Application No: LU/214/20/PL

Recommendation Report for Planning Permission

LOCATION: Empty Supermarket Premises
Avon Road
Littlehampton
BN17 6AT

PROPOSAL: Demolition of existing buildings & redevelopment comprising 36 No. residential units (Class C3) & flexible commercial floorspace (Class A1, A2, A3 and/or D1) together with the provision of car & cycle parking, landscaping & associated works (resubmission following LU/3/19/PL). This application affects the setting of listed buildings & may affect the character & appearance of the East Street, Littlehampton Conservation Area. This application is in CIL Zone 4 (Zero Rated) as 'flats & other development'.

Elevation G' | East Street Scale 1:100 @ A0

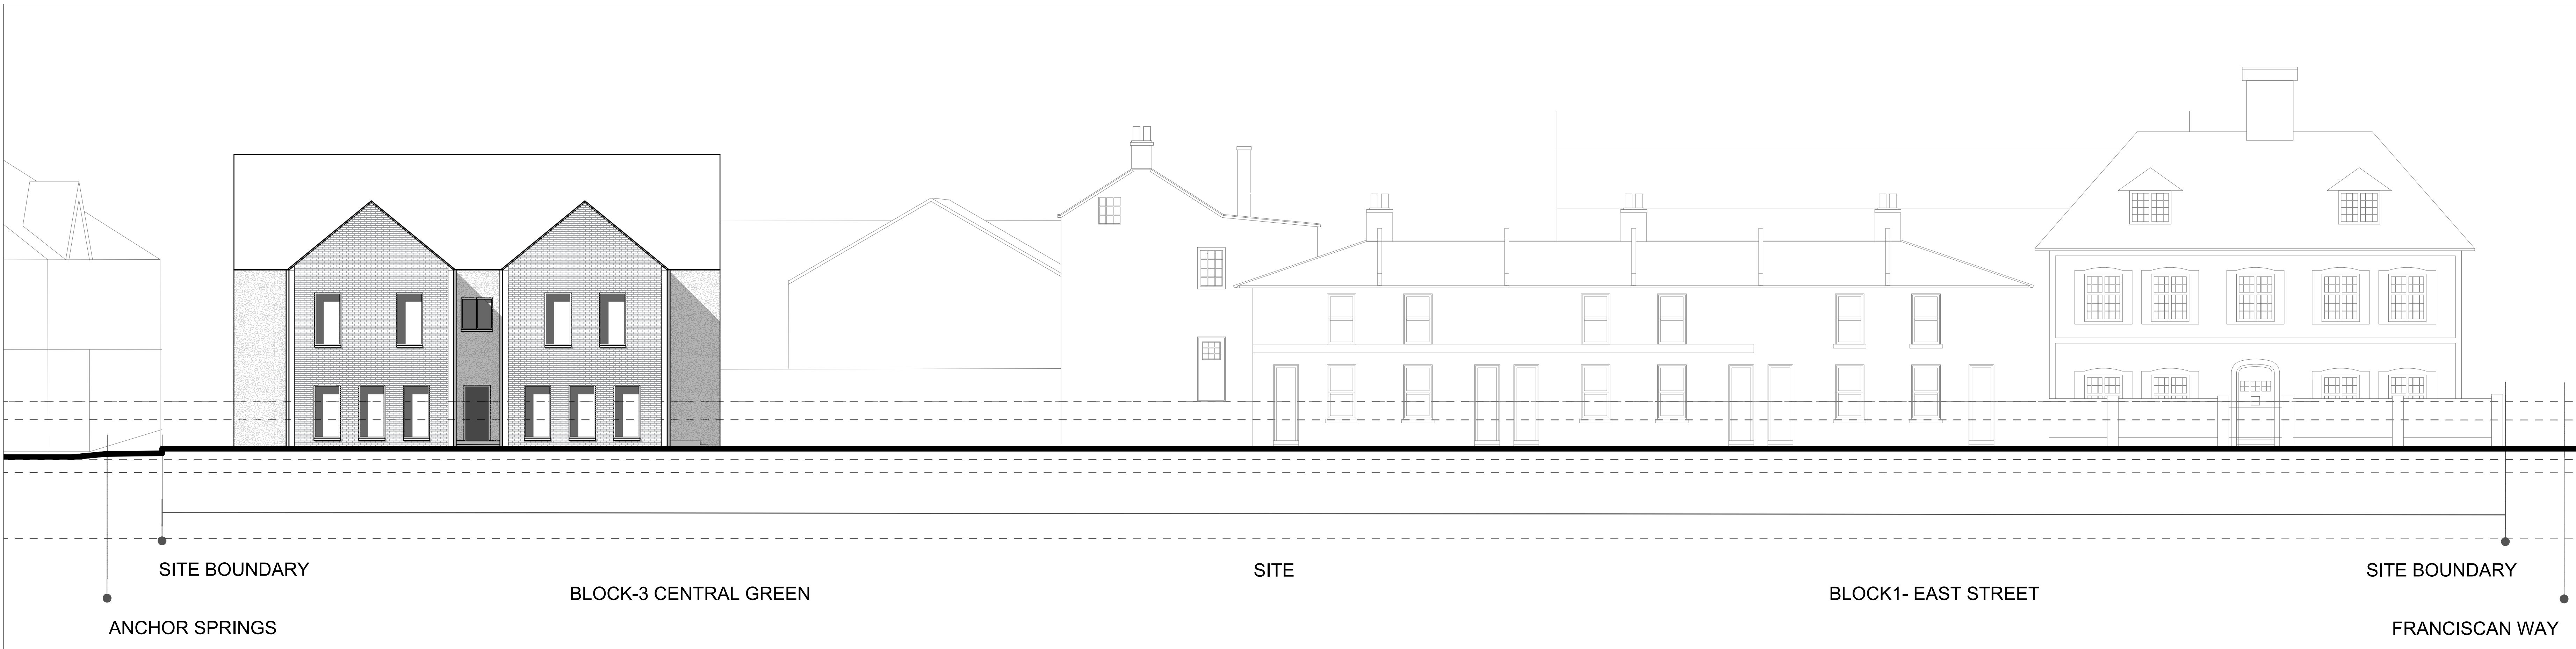
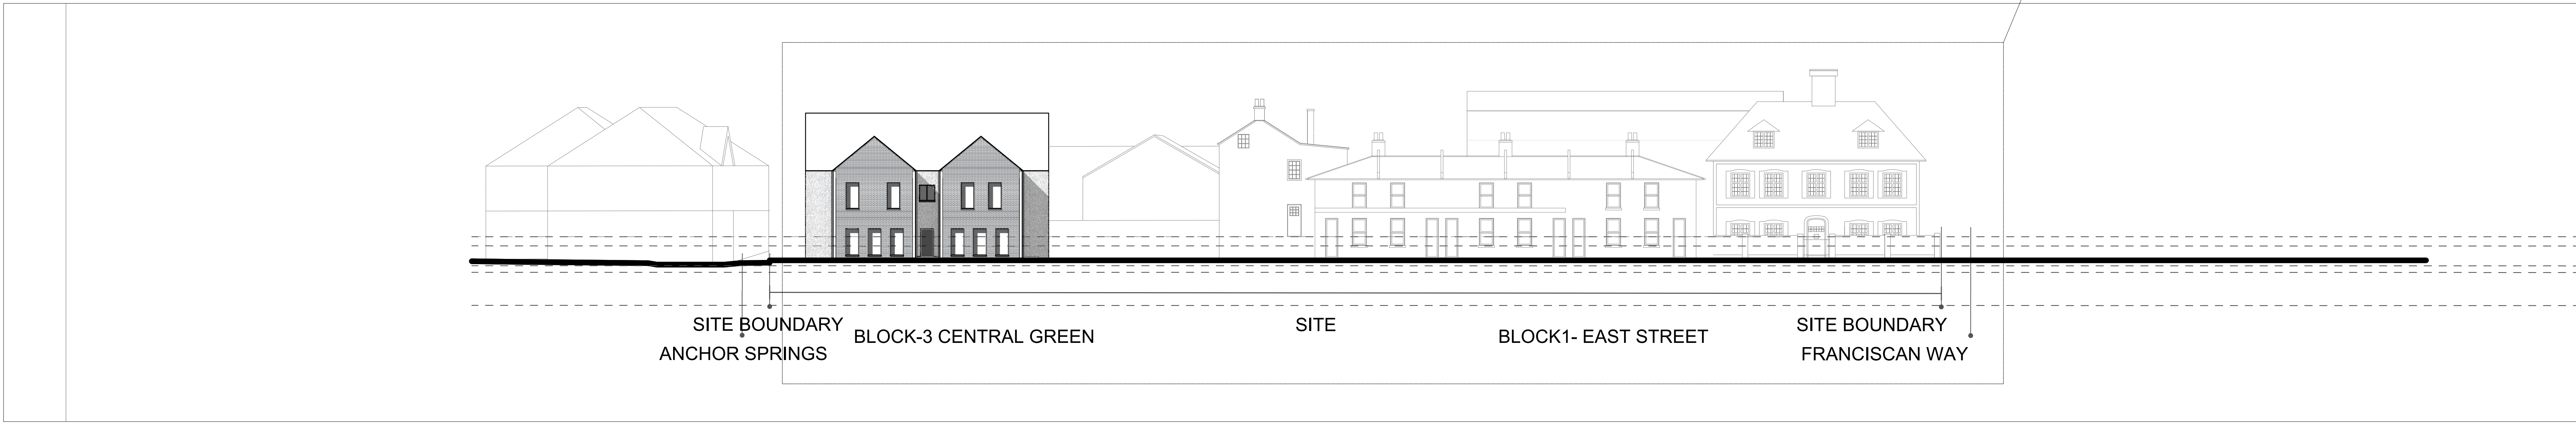
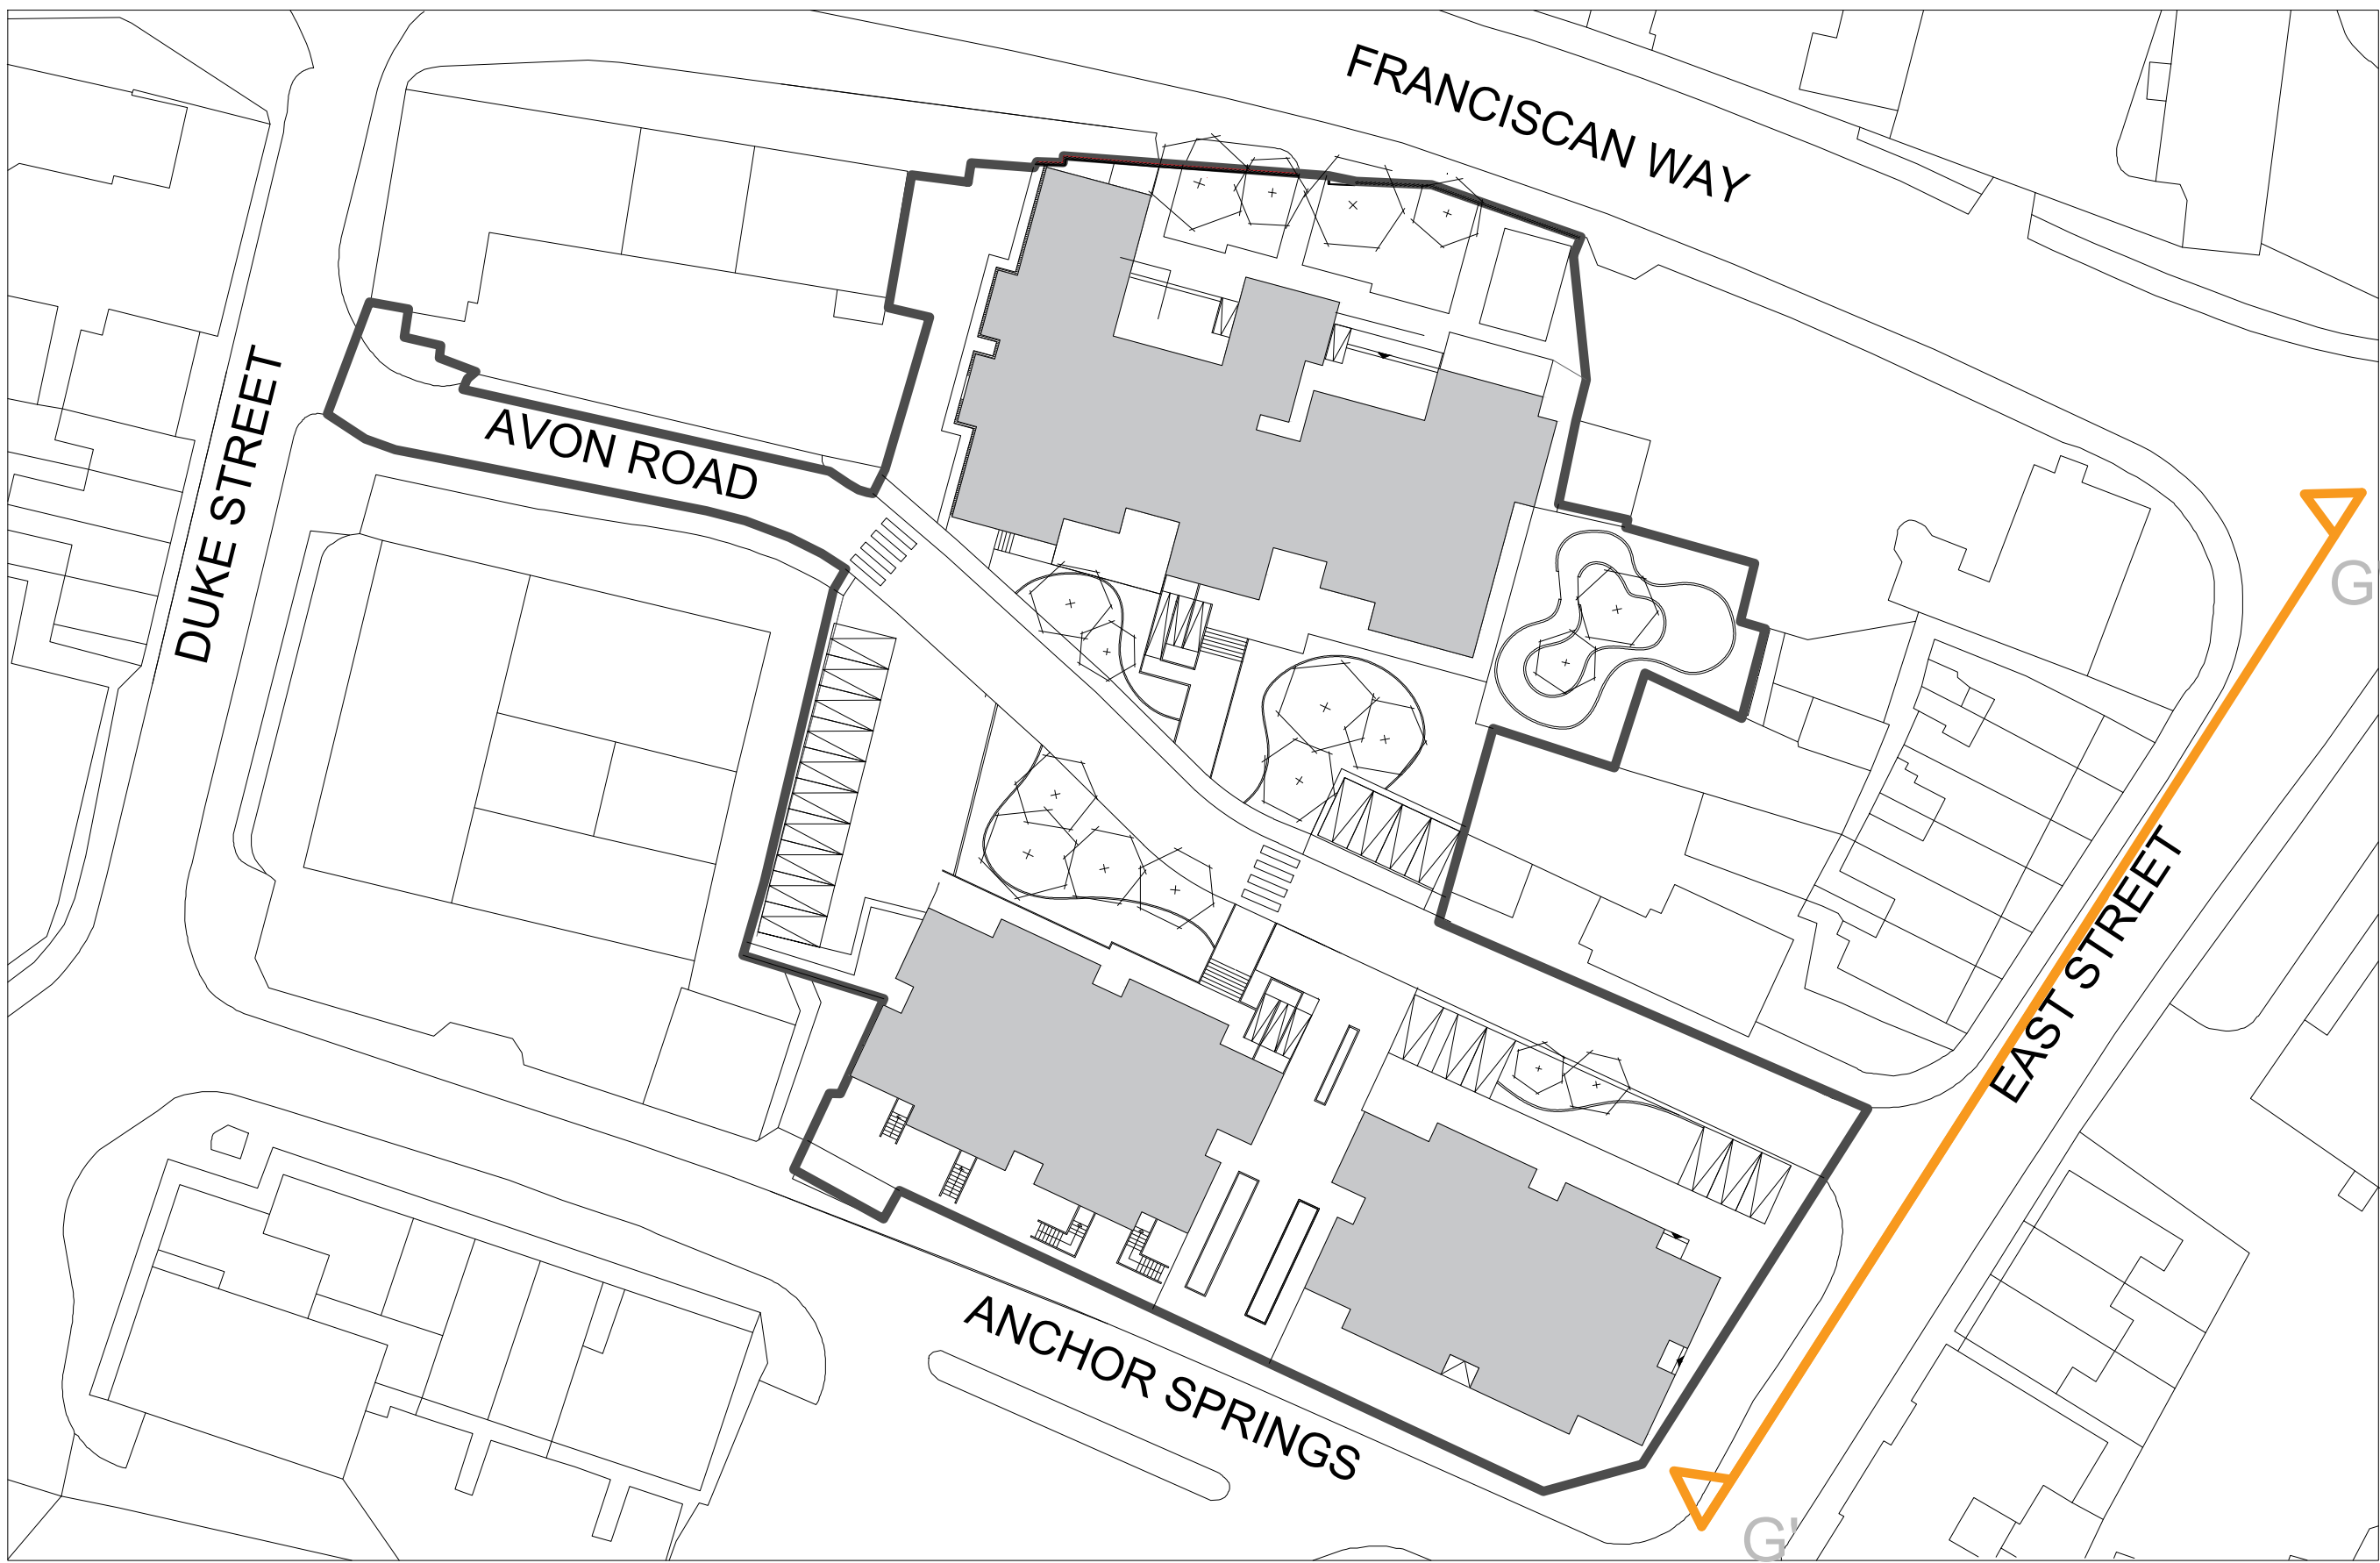
Still some concerns regarding the appearance of the development. Whilst the height of the block fronting on to East Street has been reduced in height, it is still not clear how this fully relates to the existing buildings in the local area in terms of its design.

- The block fronting East Street and the conservation area appears out of keeping in its configuration, massing, form, and fenestration treatment with the historical and good quality townscape context.
